**Consultation Response from KC,
Lead Local Flood Authority****2022/92842 The Carlton Nursing Home, 25, Greenway, Milnsbridge, Huddersfield, HD3 4RZ****Change of use and internal alterations to former nursing home (C2) to form 12 apartments (C3)****Date Responded: 16/09/2022****Responding Officer: Martin Stephenson****Responding Ref: 0****Documents reviewed by the LLFA:**

UH Design:

- Drawing Ref: 2206/01, Existing Layout & Elevations, Rev – dated August 2022
- Drawing Ref: 2206/02, Proposed Layout & Elevations, Rev – dated August 2022
- Drawing Ref: 2206/03, Proposed Parking & Amenity, Rev – dated August 2022

Proposed Site Layout 1.100

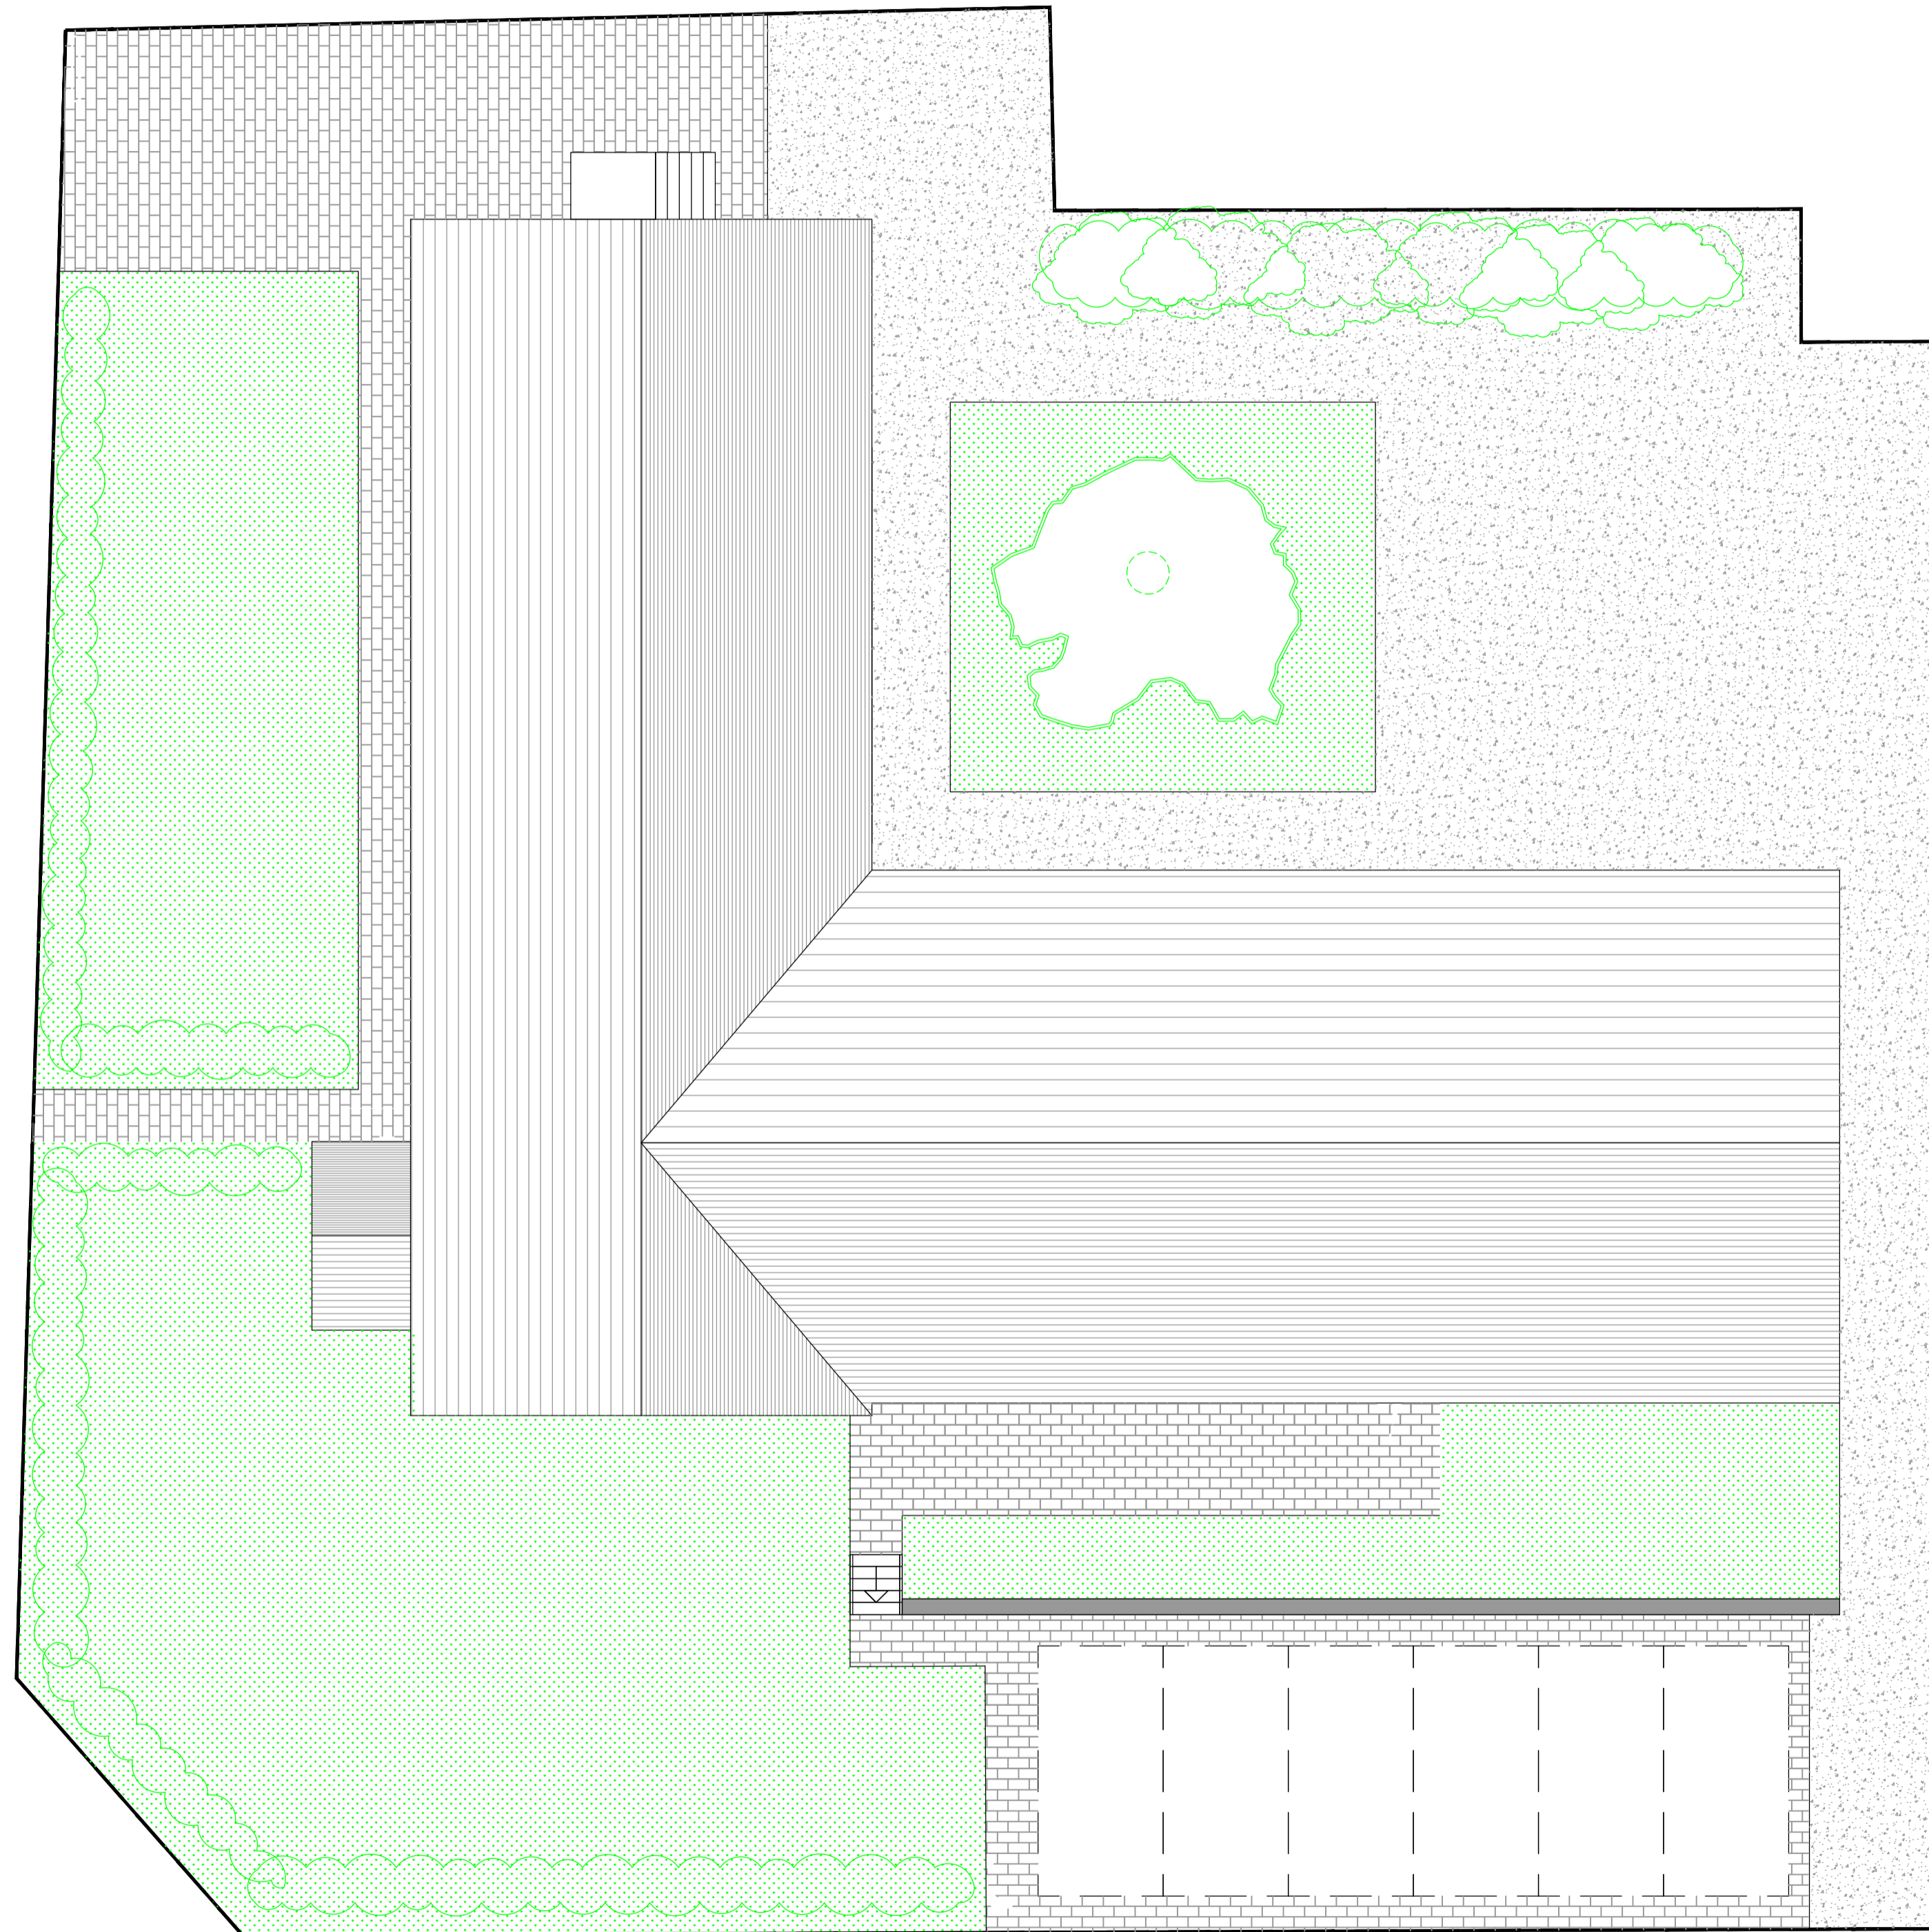
The building footprint remains the same following conversion of the former care home into residential flats, however the developer is proposing to provide parking spaces in areas which are currently grassed landscaping. The developer should restrict the surface water run-off from the new hardstanding areas to **3.5 l/s** and provide attenuation storage for the critical 1 in 100 year rainfall event plus 30% climate change such that no flooding occurs within or off the site. The point of discharge of the attenuated hardstanding drainage shall be to the 600mm dia culvert in Greenway, subject to Land Drainage Consent.

Alternatively, the surfacing of the new hardstanding areas should be of the permeable type to allow soakage into the ground (if feasible, subject to approval of soakage tests) with no positive drainage provision.

The developer should submit a Maintenance Plan including a Maintenance Schedule to the LPA for approval and should identify which organisation will be responsible for the maintenance of the car parking areas and any positive surface water drainage system or permeable paved hardstanding areas.

The development shall not commence until a detailed design scheme detailing foul, surface water and land drainage, including (unless permeable paving of the hardstanding areas is proposed) an agreed discharge rate with the LLFA of **3.5 l/s** draining to the Greenway culvert, attenuation for the critical 1 in 100 + 30% climate change rainfall event, attenuation construction details /design, plans and hydraulic calculations, phasing of drainage provision has been submitted to and approved in writing by the Local Planning Authority. The scheme shall include a risk assessment and method statement, in accordance with CDM Regulations 2015, for access to and into the attenuation structure, and the scheme shall include a maintenance and management plan for the surface water infrastructure or permeable paved areas. No part of the development shall be occupied until such approved drainage scheme has been provided on the site to serve the development or each agreed phasing of the development and retained thereafter.
